Date: 01-Dec-2025  
Our Ref: 2025/92875

**TOWN AND COUNTRY PLANNING ACT 1990  
TOWN AND COUNTRY PLANNING (GENERAL PERMITTED DEVELOPMENT) (ENGLAND)  
ORDER 2015 – SCHEDULE 2, PART 1, CLASS A.1 (g)  
AT: Squirrel Lodge, 19, Liversedge Hall Lane, Liversedge, WF15 7DP  
Prior notification for single storey rear extension**

The proposal is for erection of single storey rear extension. The extension projects 8m beyond the rear wall of the original dwellinghouse. The maximum height of the extension is 4m, the height of the eaves of the extension is 3m.

PROPOSED SITE PLAN

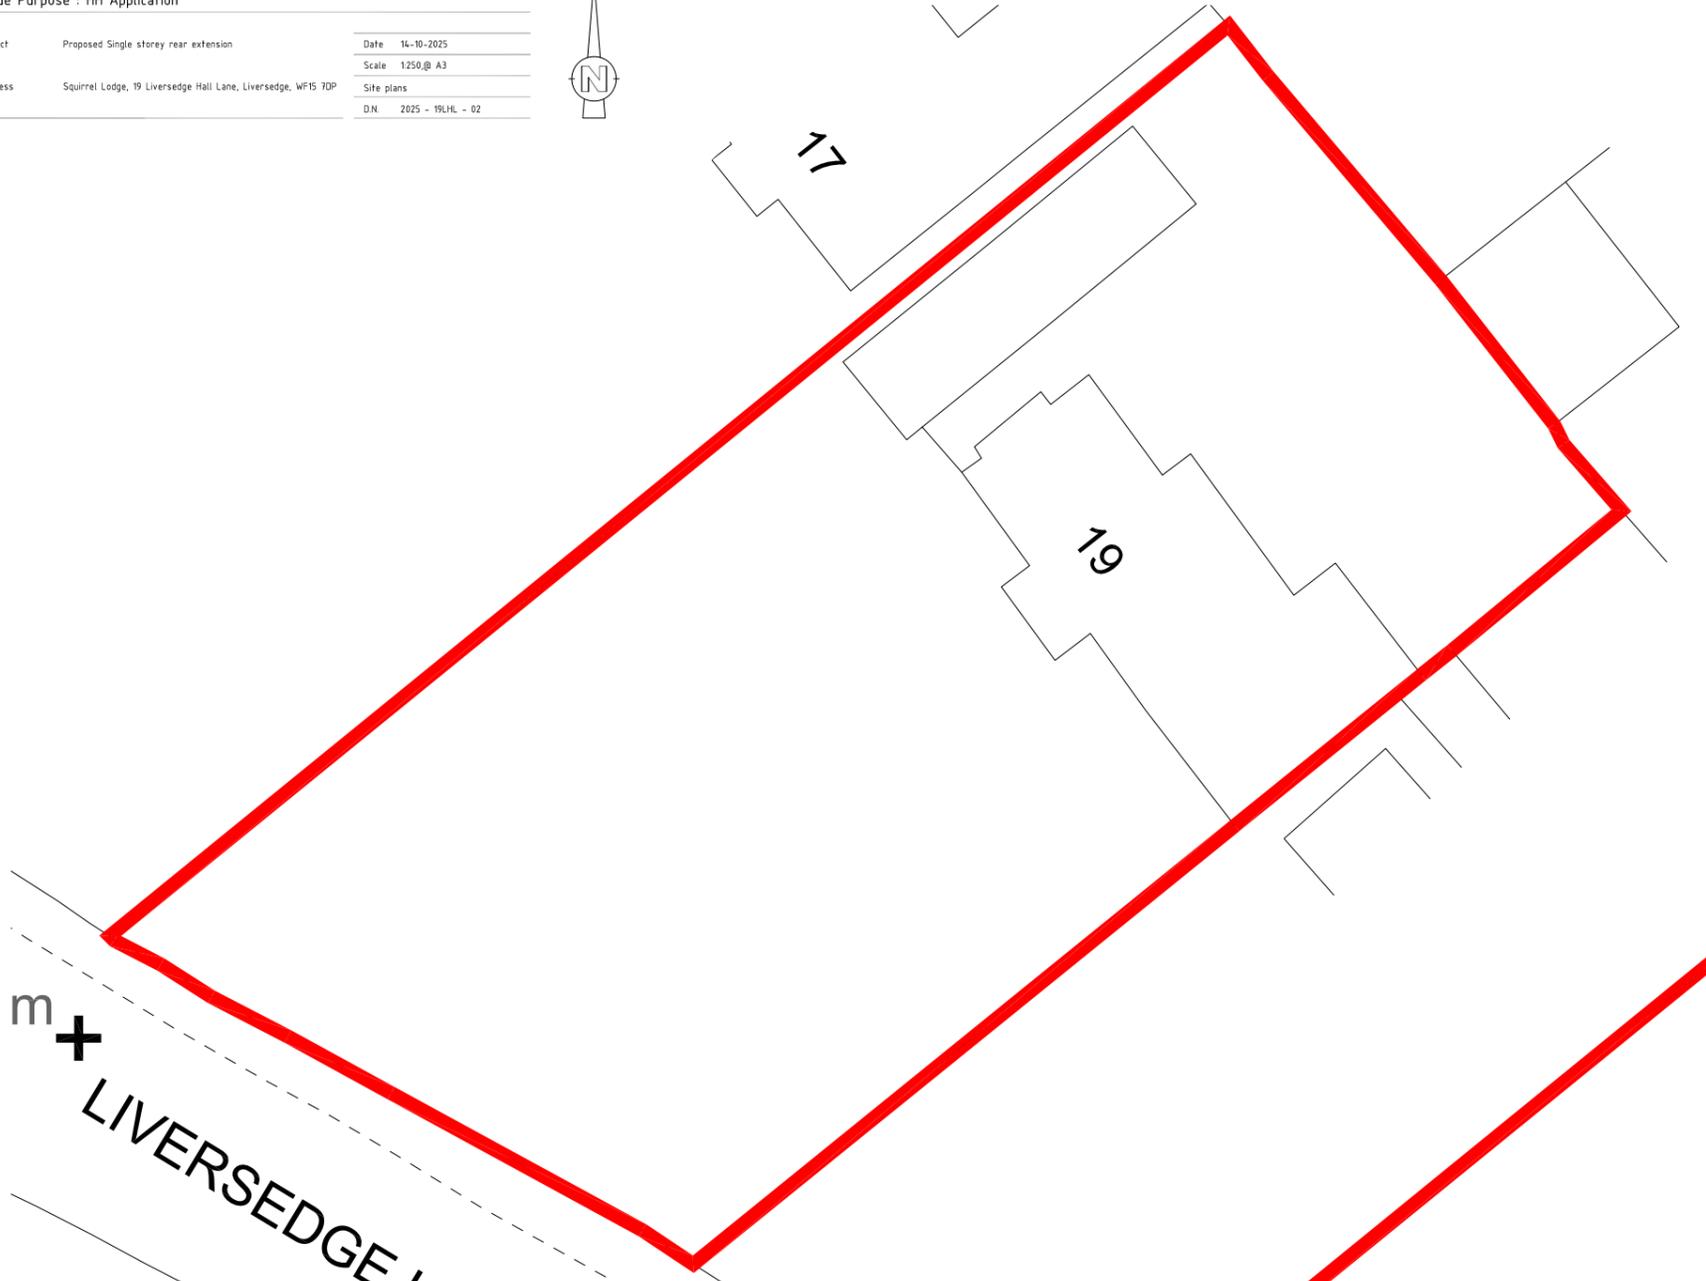
Therefore, the proposed enlargement cannot benefit from a general planning permission under Article 3(1) and Schedule 2, Part 1, Class A of the Town and Country Planning (General Permitted Development) (England) Order 2015 (as amended), Schedule 2, Part 1, Class A as the enlarged part of the dwellinghouse would extend beyond walls forming a side elevations of the original dwellinghouse and would have a width greater than half the width of the original dwellinghouse contrary to sub-paragraph A.1(j) & A.1(ja) of Class A.
